Our Ref: FP/42/20/HH
Your Ref:

Town & Country Planning Act 1990 (as amended)
Town & Country Planning (Development Management Procedure) (England) Order 2015
Application for Planning Permission for Works or Extension to a Dwelling

Development Single story conservatory to rear elevation

Location 7 Meaden Way Felpham

BLOCK/SITE PLAN
AREA 90m x 90m
SCALE 1:500 on A4
CENTRE COORDINATES: 495623, 100883

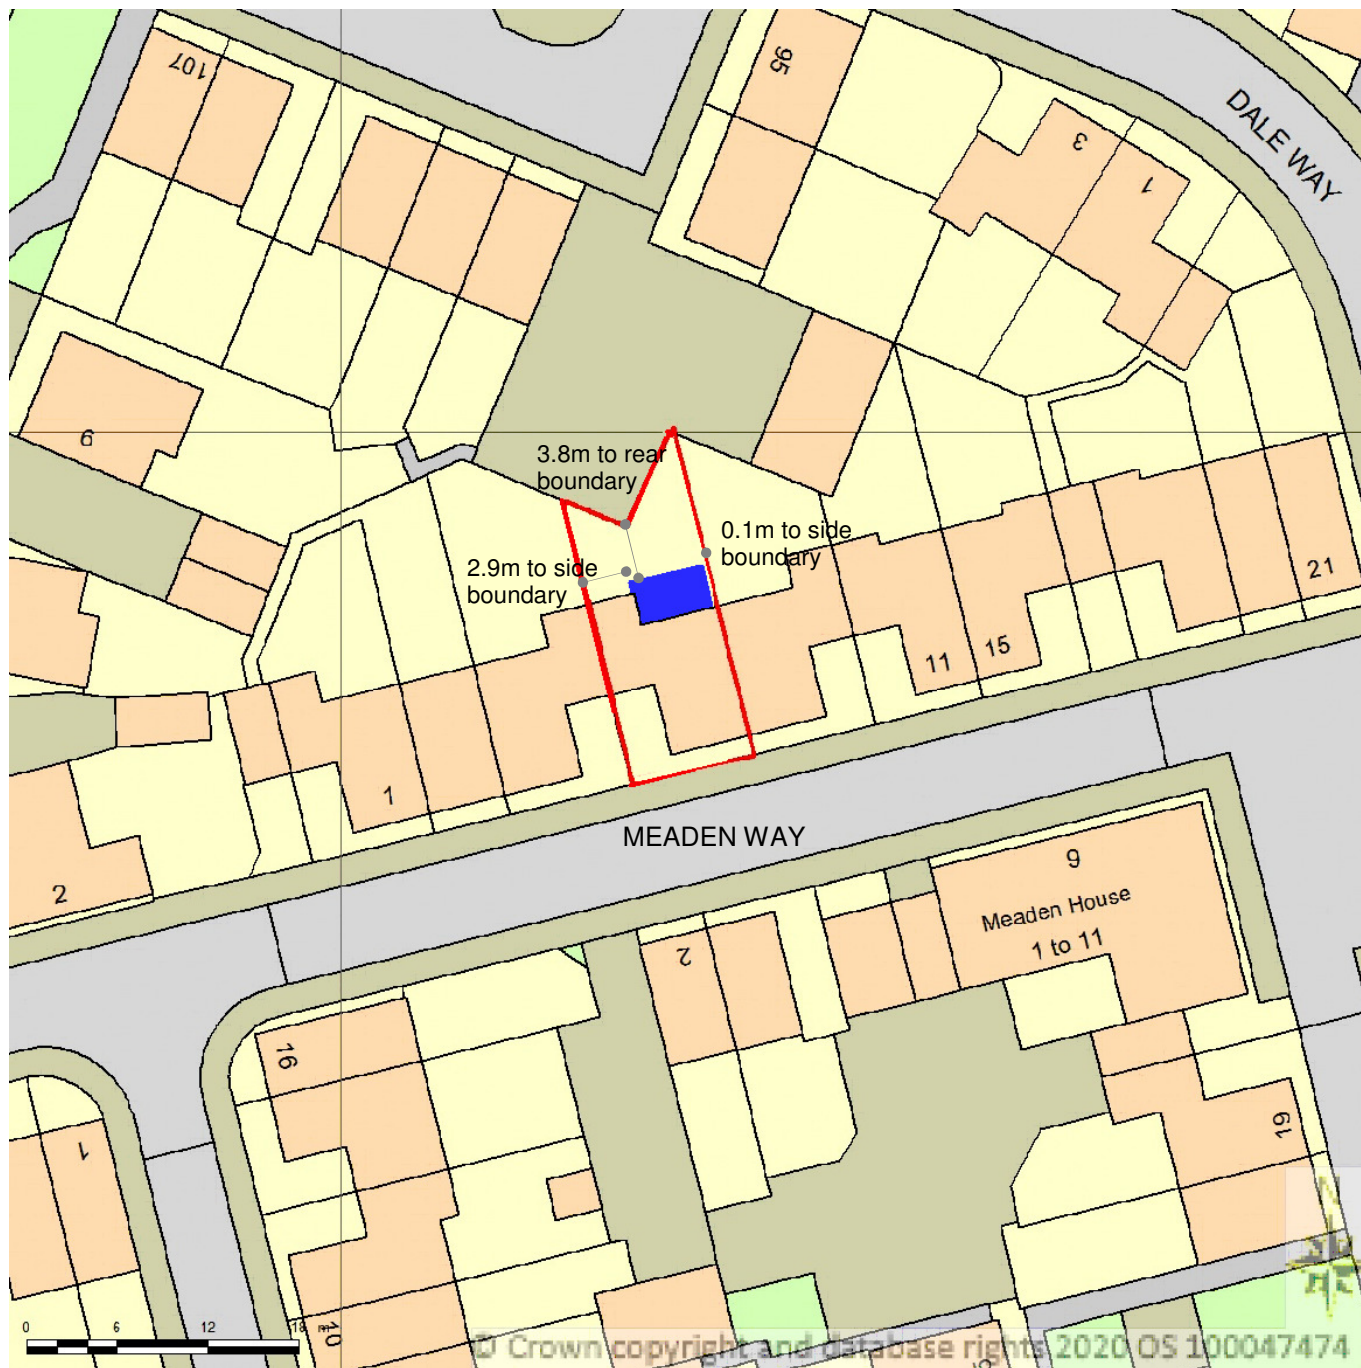
Size of extension inconsistent between the block plan and all other plans.

Drawing
**PROPOSED FLOOR PLAN
& ELEVATIONS**

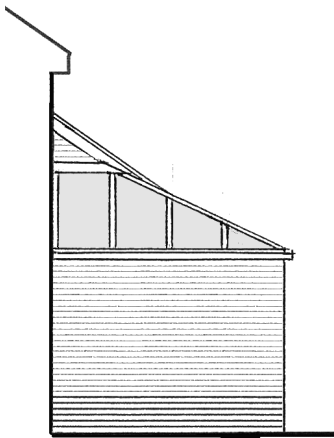
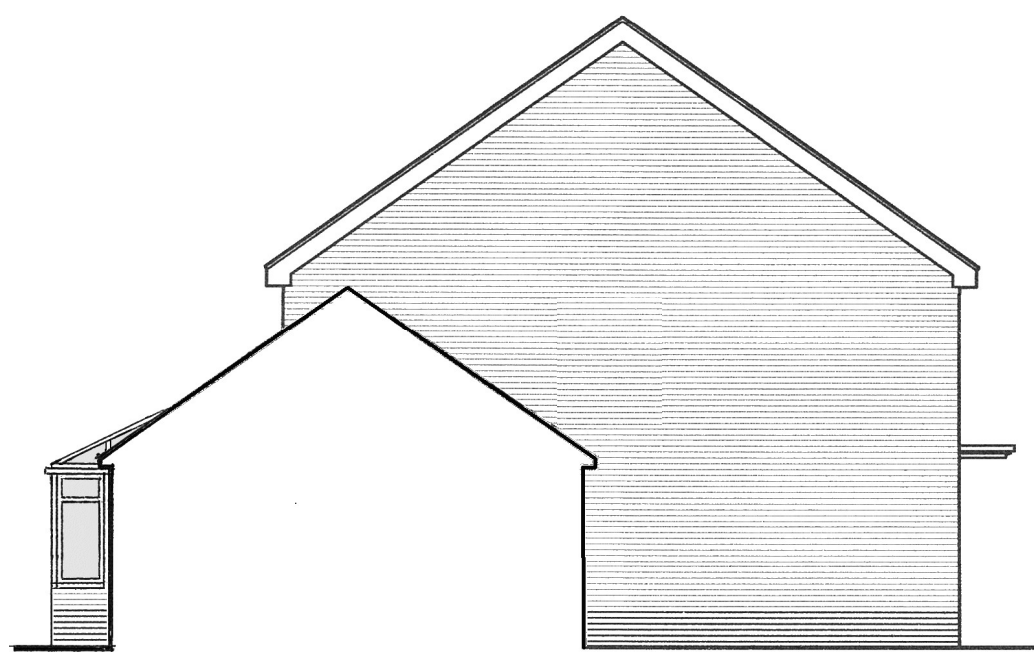
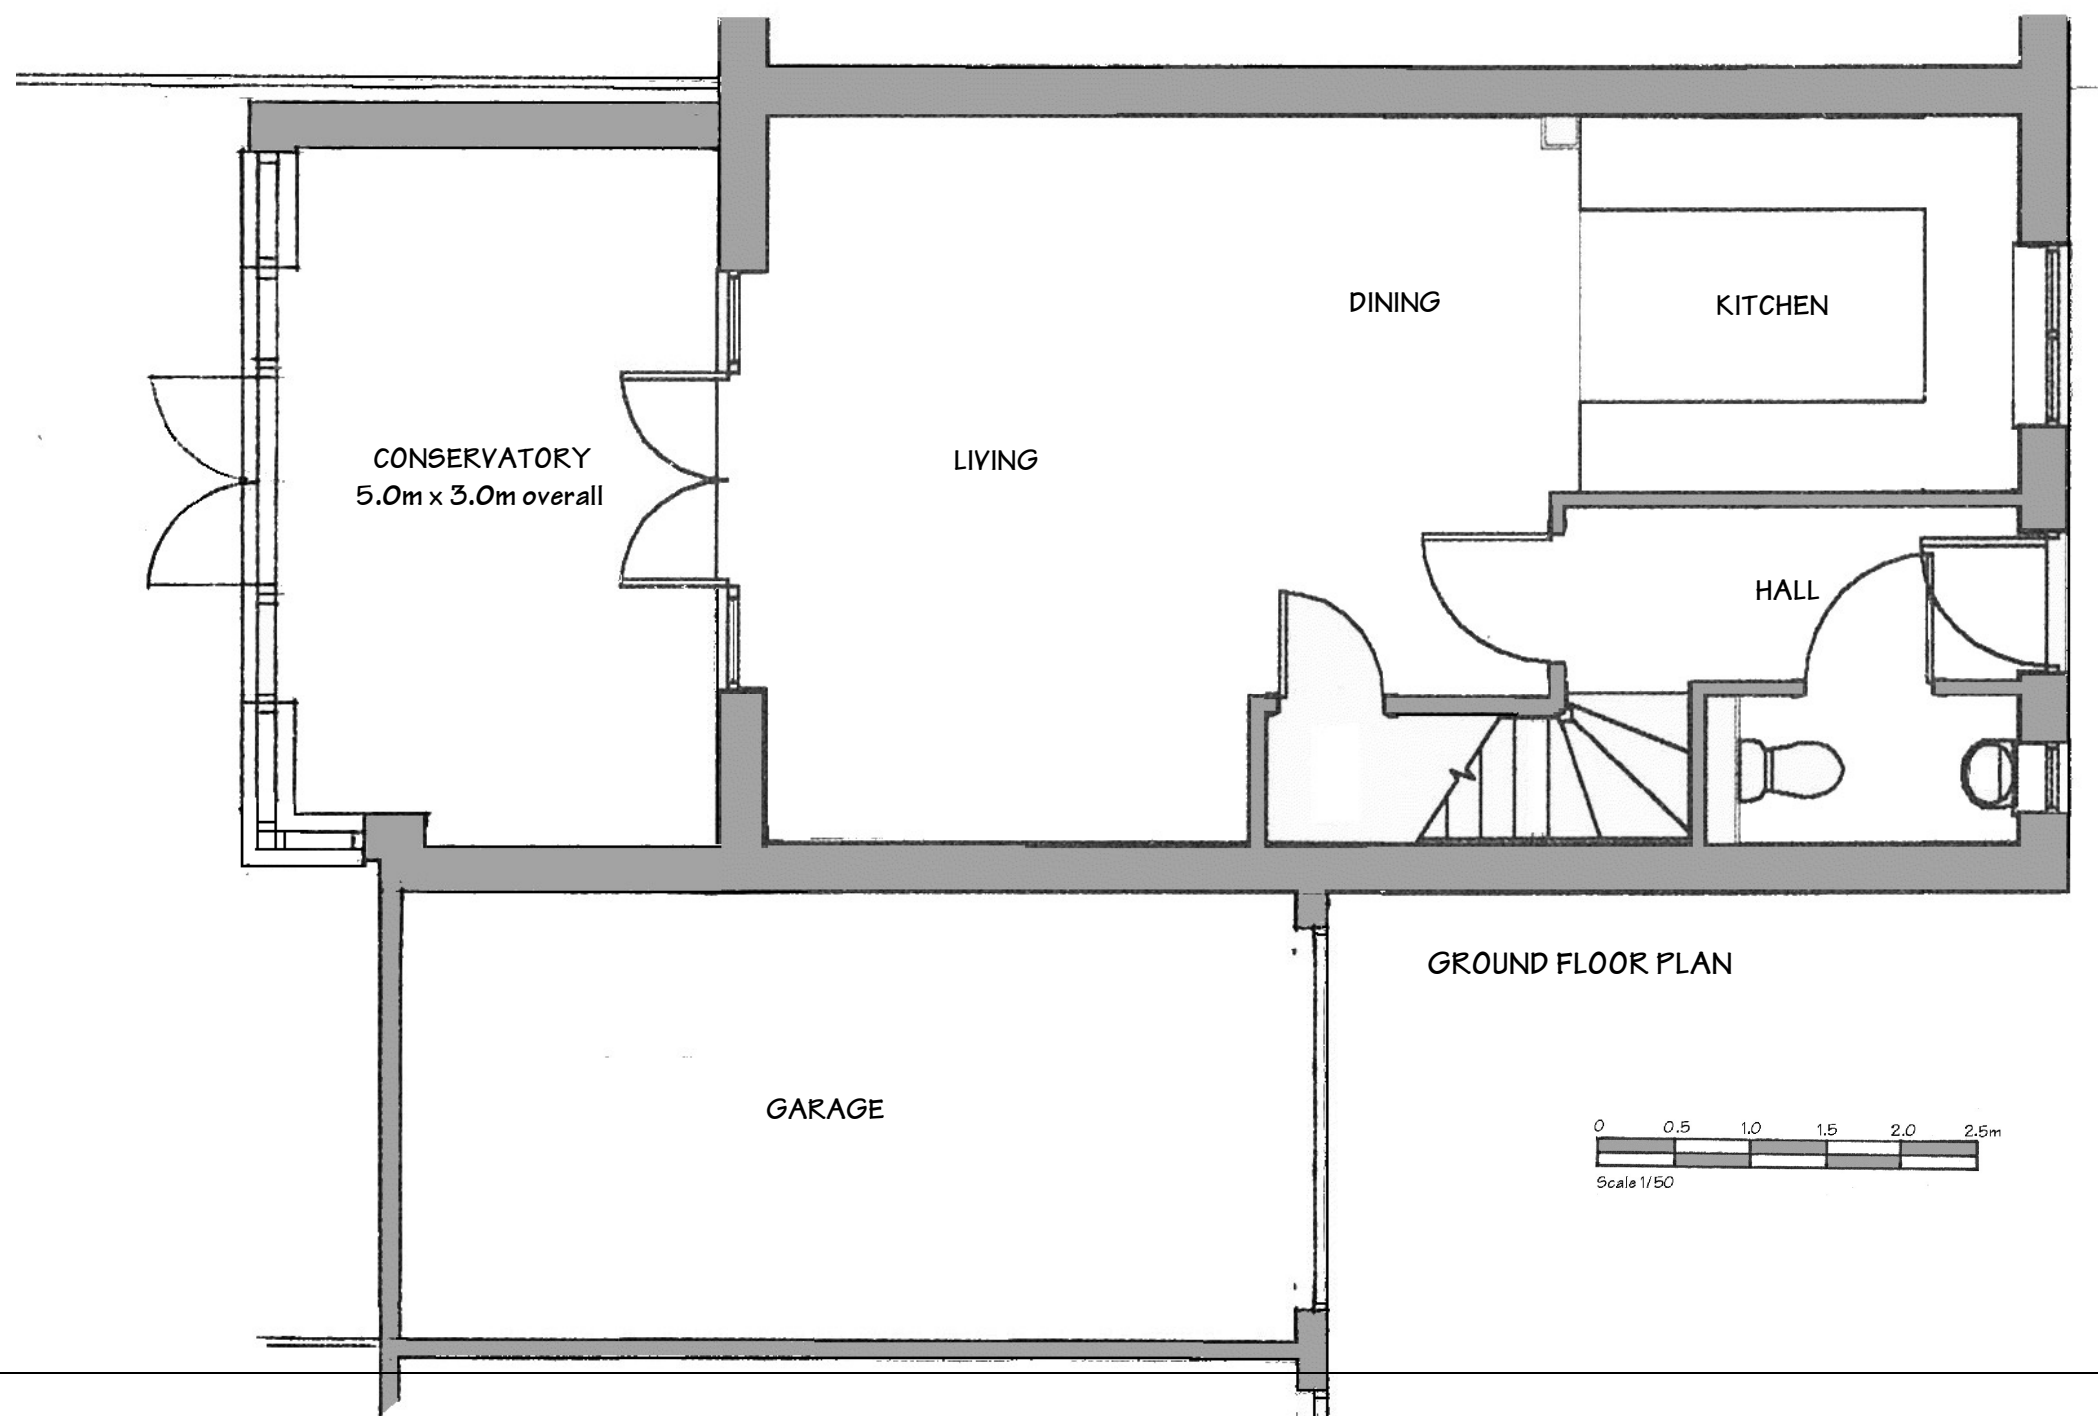
Dimension: Please include a dimension to the other side boundary or with your permission we can add it for you.
